Objection to planning application 2024/62/93458/E

I strongly object to the proposed development of 62 new houses on Cliffe Hill, Cumberworth lane

PROPOSED
SITE PLAN

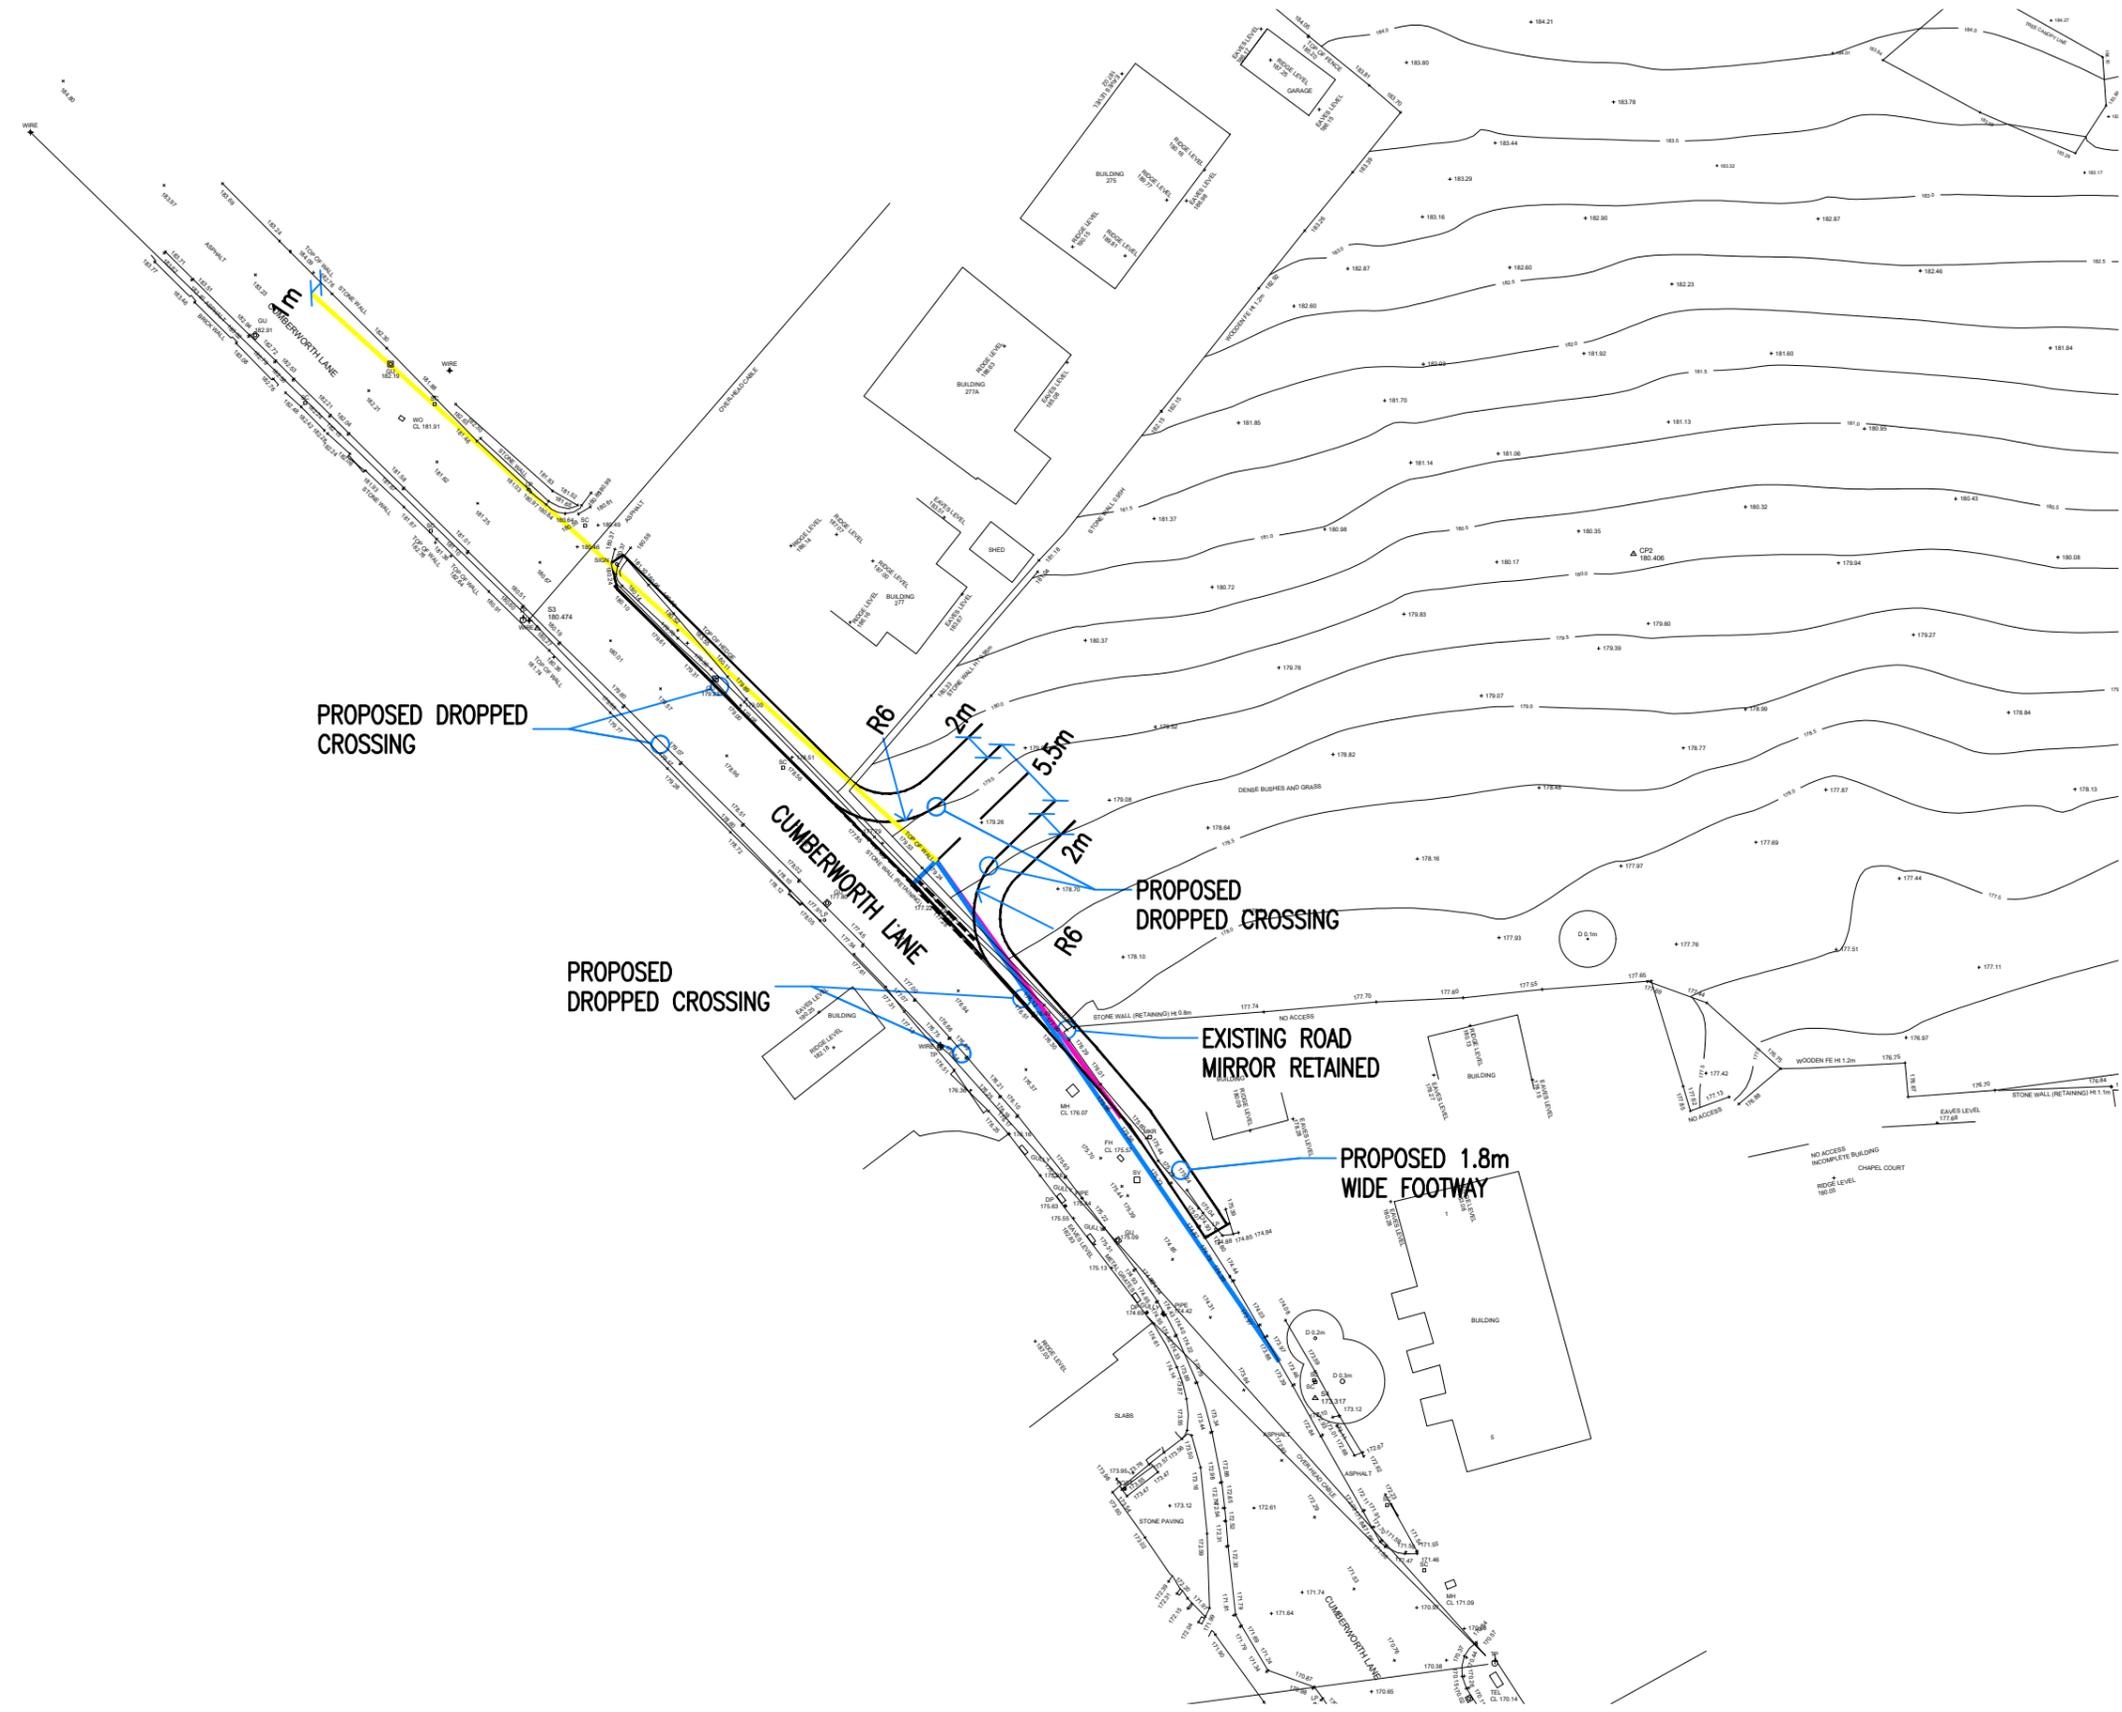
The new development drawings show 2 new pedestrian connections from the new site directly onto the public footpath (PROW DEN/61/10) – this footpath/right of way is unlit and these 2 access points could lead to risks to personal safety as the connections will be blind onto the footpath, high potential for crime risk and anti-social behaviour.

One of the proposed new pedestrian access points states that there are steps needed due to level differences - how is this suitable for less abled persons , families with prams ?

PROPOSED ACCESS ARRANGEMENT

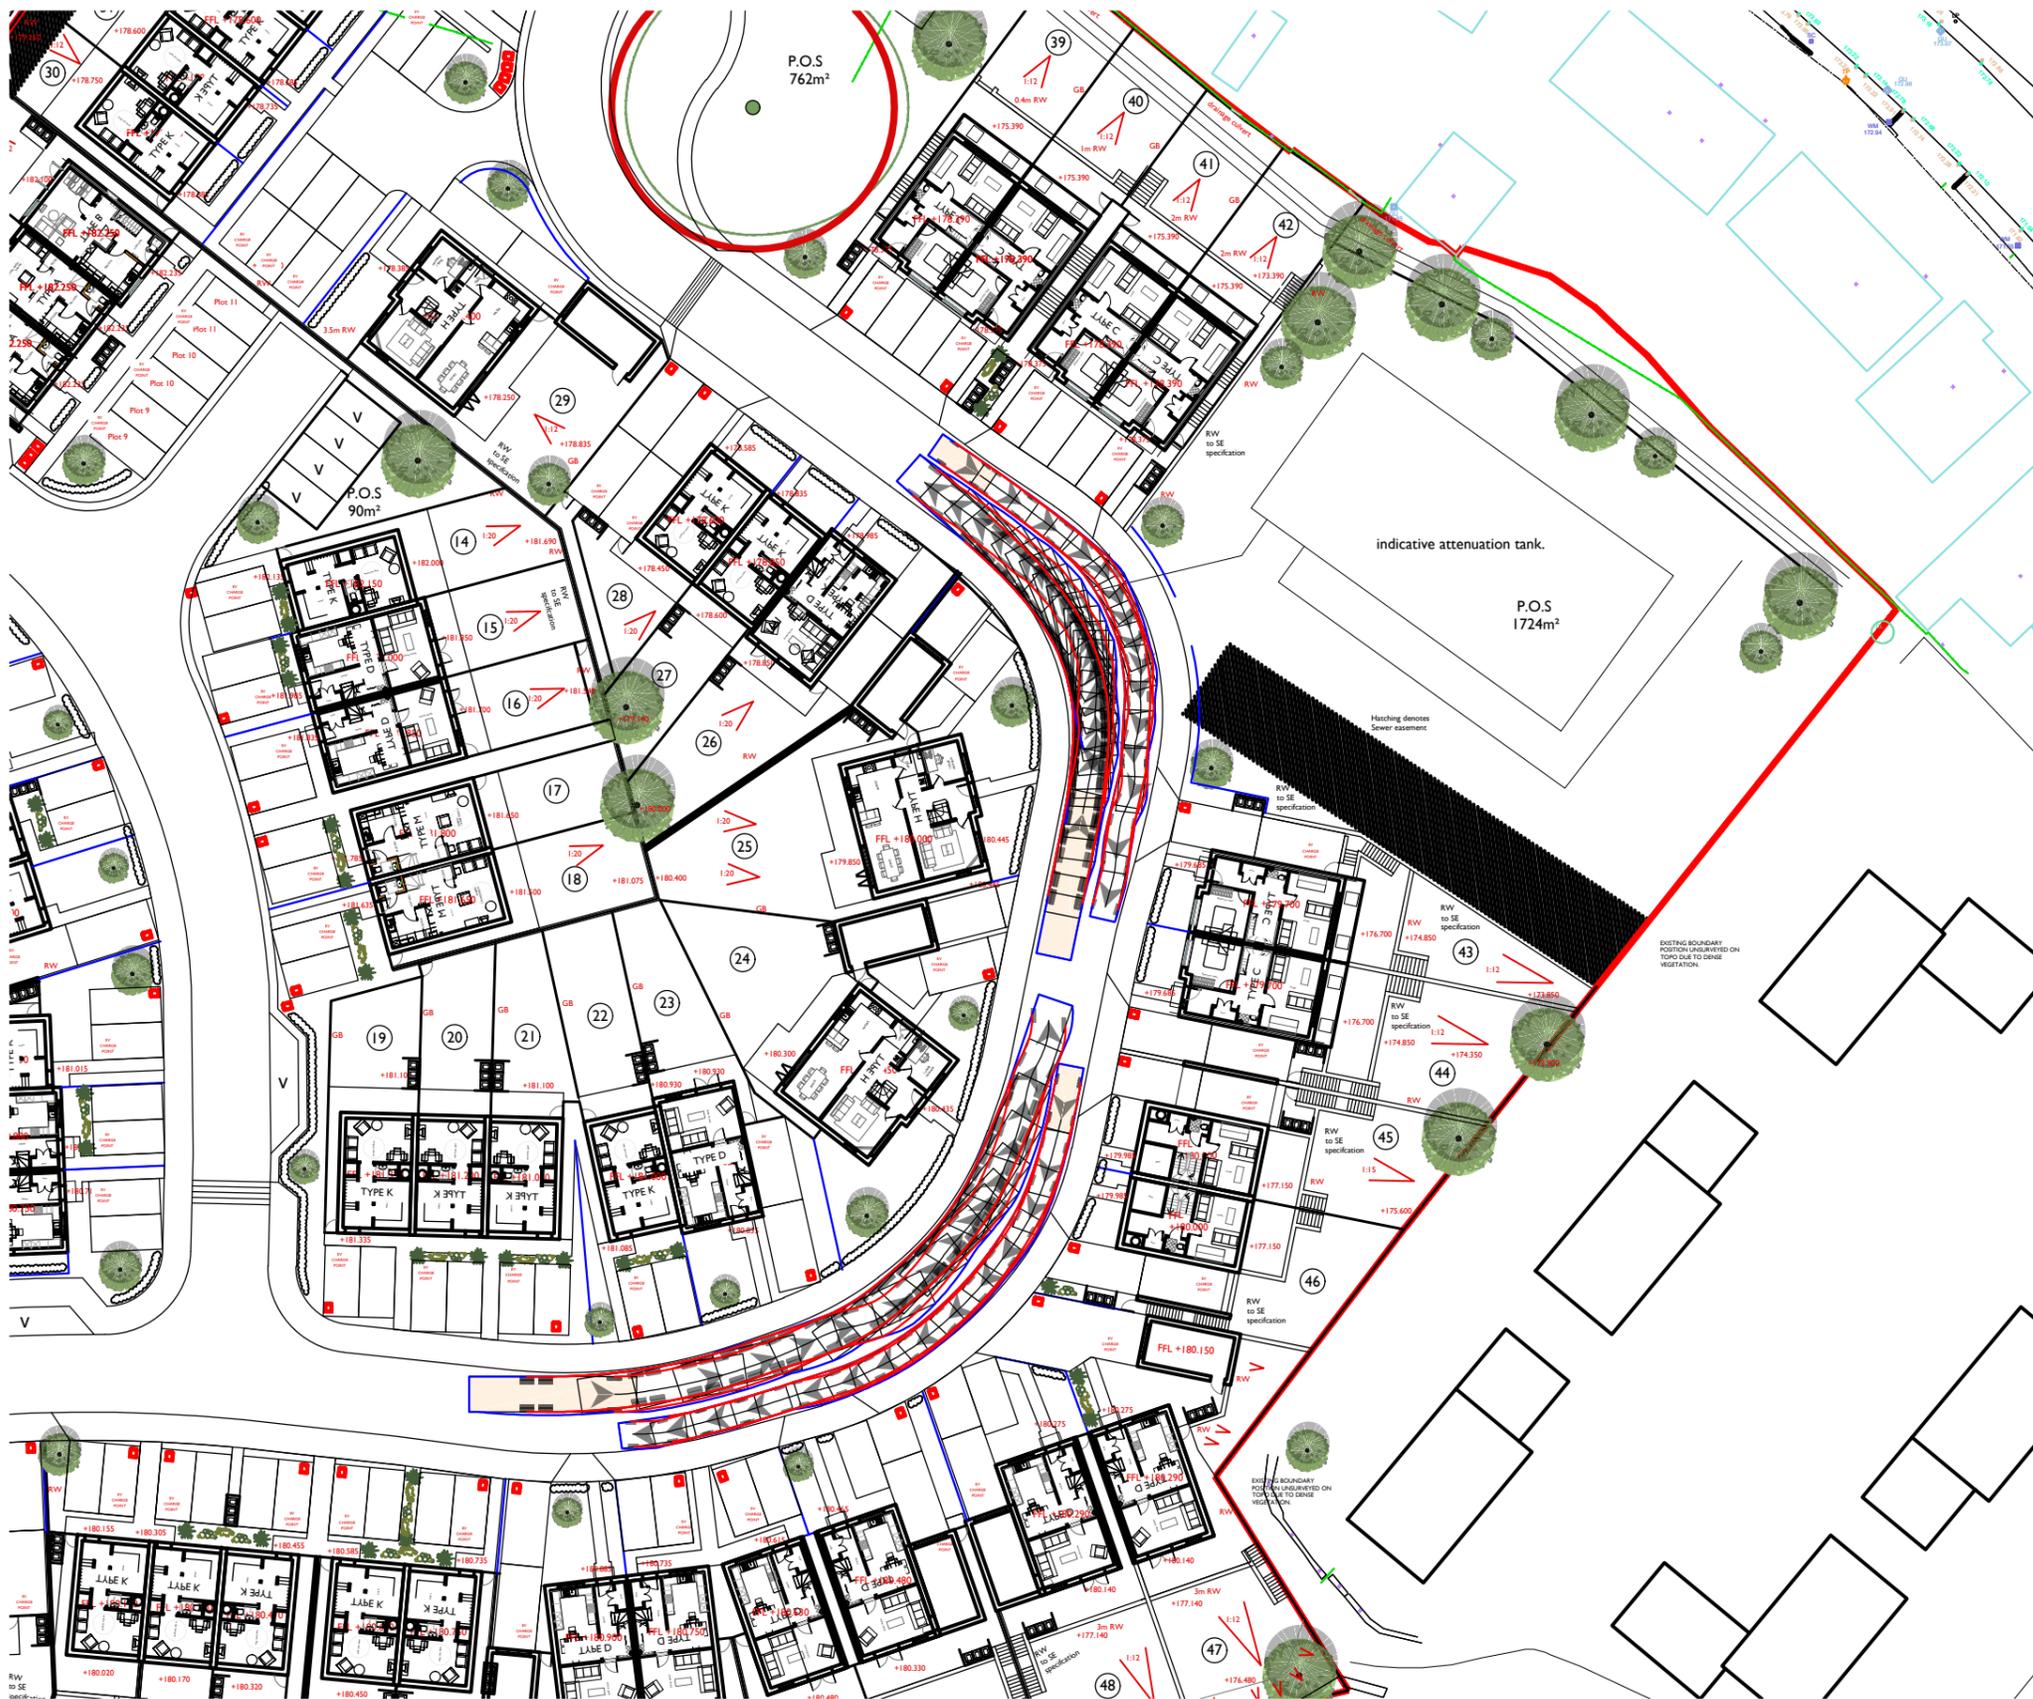
The location for entry and exit to the proposed development on Cumberworth Lane is in the worst possible location for the following reasons:

- It is at a point where the road narrows by the Methodist Church.
- The footpath at this location is very narrow only 0.9m wide, not enabling anyone to walk side by side, including those with young children, wheelchair users, parents with prams - there is only footpath on one side of the road at this point.

- Parking by residents below this point means that larger traffic, including buses, lorries, farm vehicles tractors often must wait to pass. There is insufficient space on this narrow road for 2 large vehicles to pass safely. HGV's have been witnessed driving onto the narrow pavement to pass other vehicles.

- Visibility splays at this location are poor up hill and down the hill towards the White Hart Pub.
- Large vehicles will have to swing out into the oncoming traffic to turn in and out of proposed development.

- There are significant level differences from Cumberworth Lane to the proposed site access road with a steep incline approaching 2m - there is a risk of cars exiting site in poor weather sliding out into the oncoming traffic. This steep incline will also pose serious risks to pedestrians, young children, pram users and wheelchair users ending up in the busy road.
